## **DEPARTMENT OF PUBLIC WORKS**

**TO:** All Staff  
**FROM:** Public Works Planning Review Team  
**DATE:** March 10, 2021  
**SUBJECT:** VA-21-00003 Ward

SITE PLAN

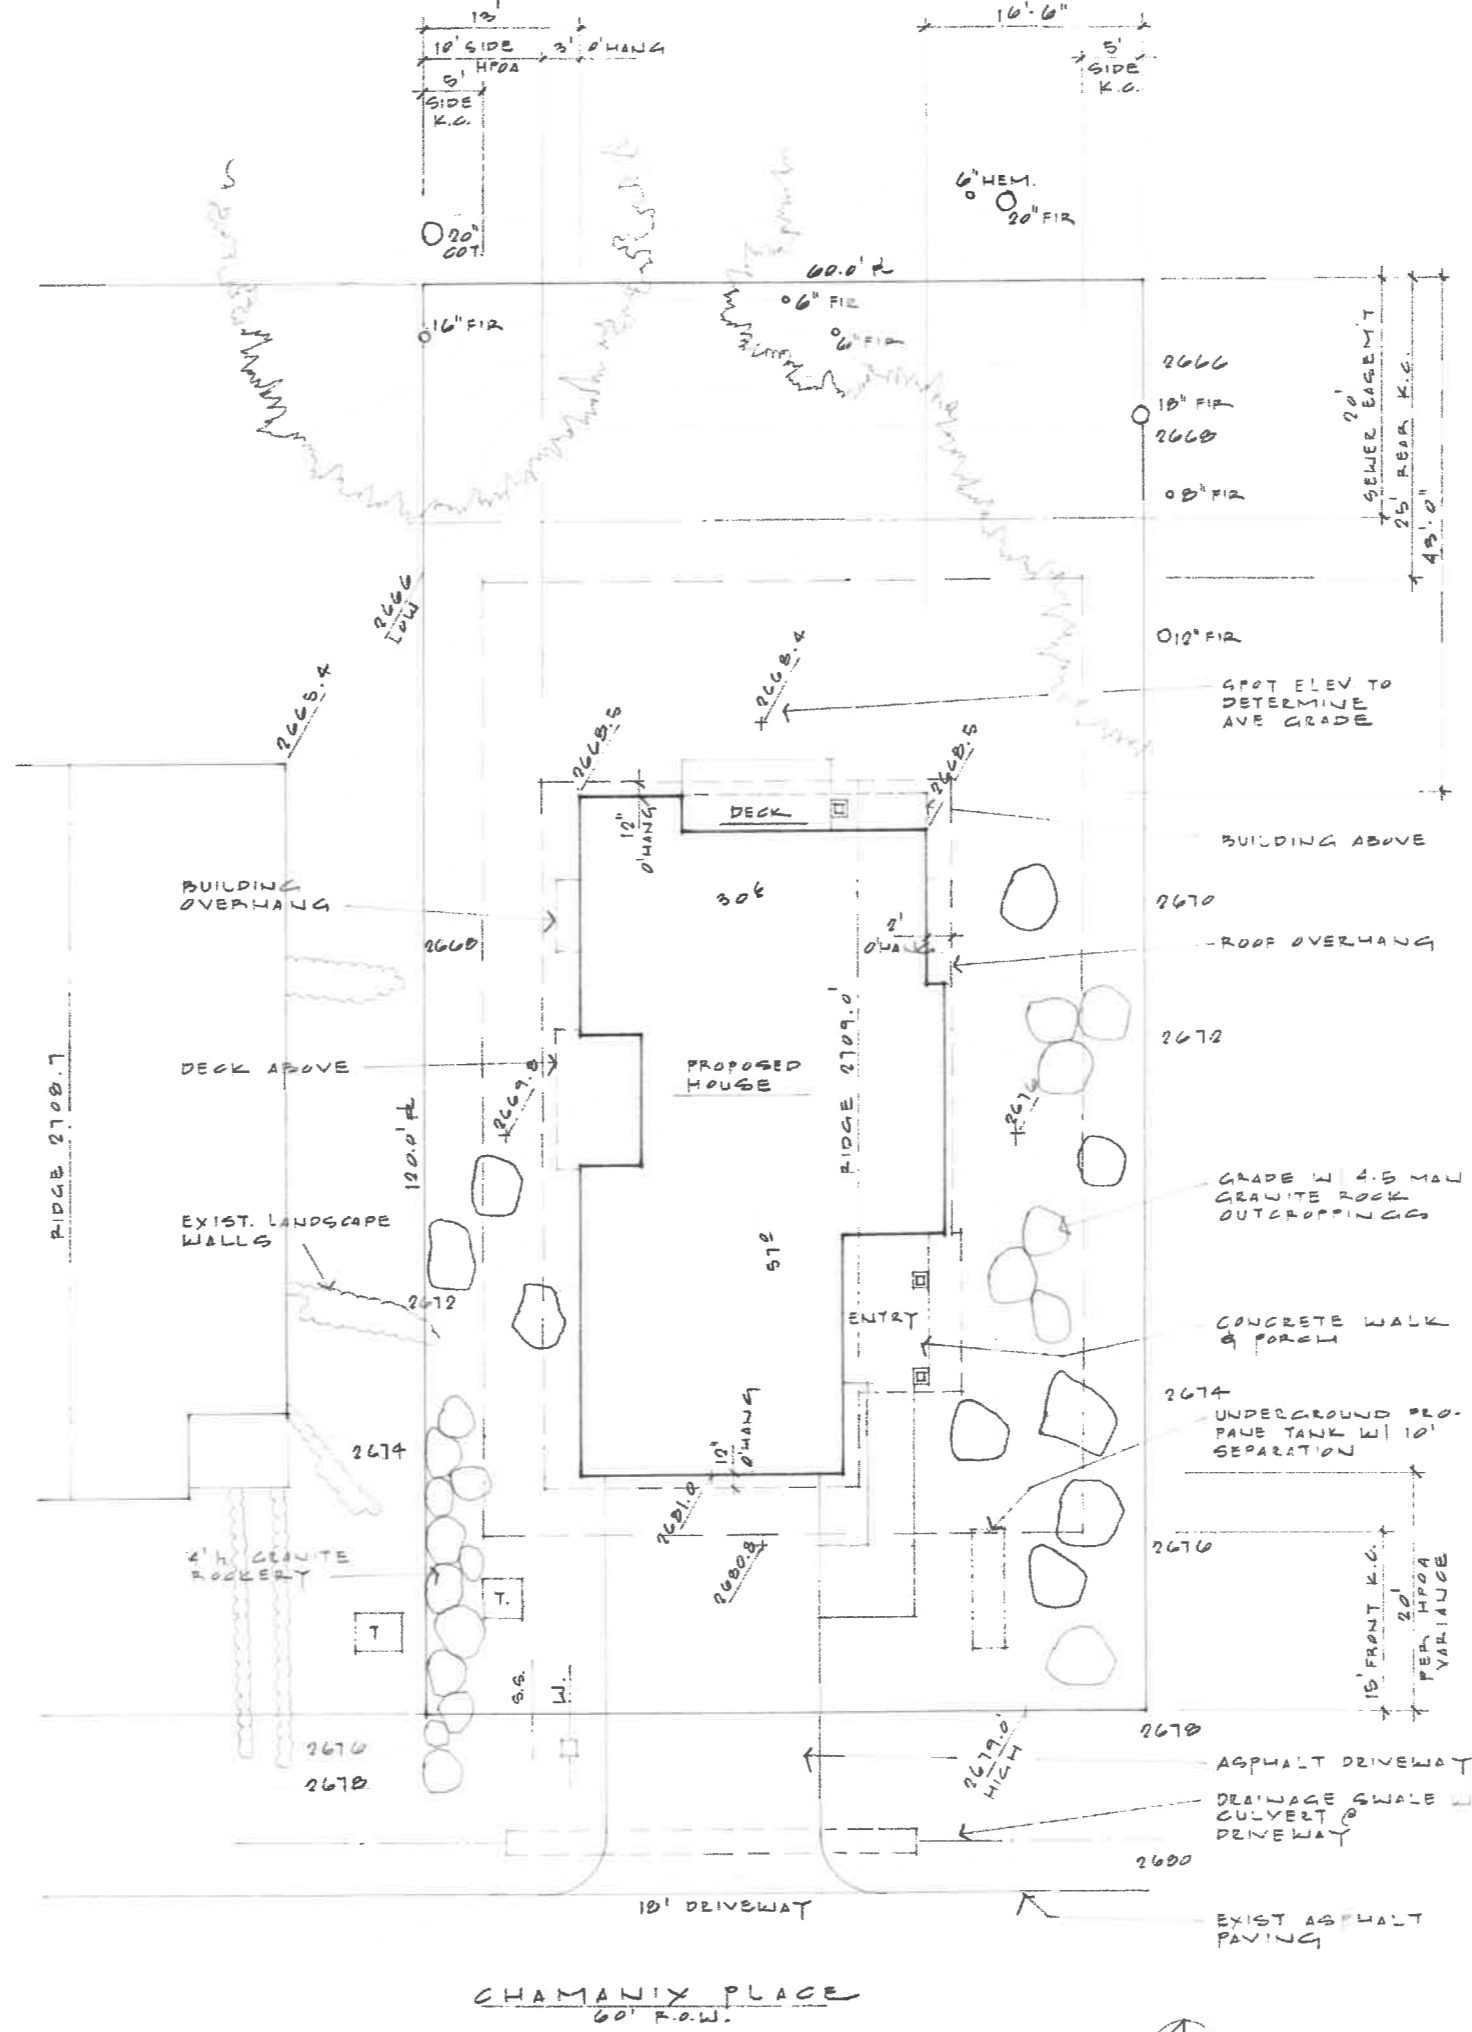
- A. An access/address permit would be required when a building permit is applied for.
- B. The structure will not encroach upon any easement or right-of-way. Please be sure to keep permanent structures and large boulders out the Kittitas County Right of Way as well.
- C. Any grading over 100 cubic yards of material will require a grading permit from Public Works.
- D. Applicant is required to provide information on how the property line/right of way was determined.
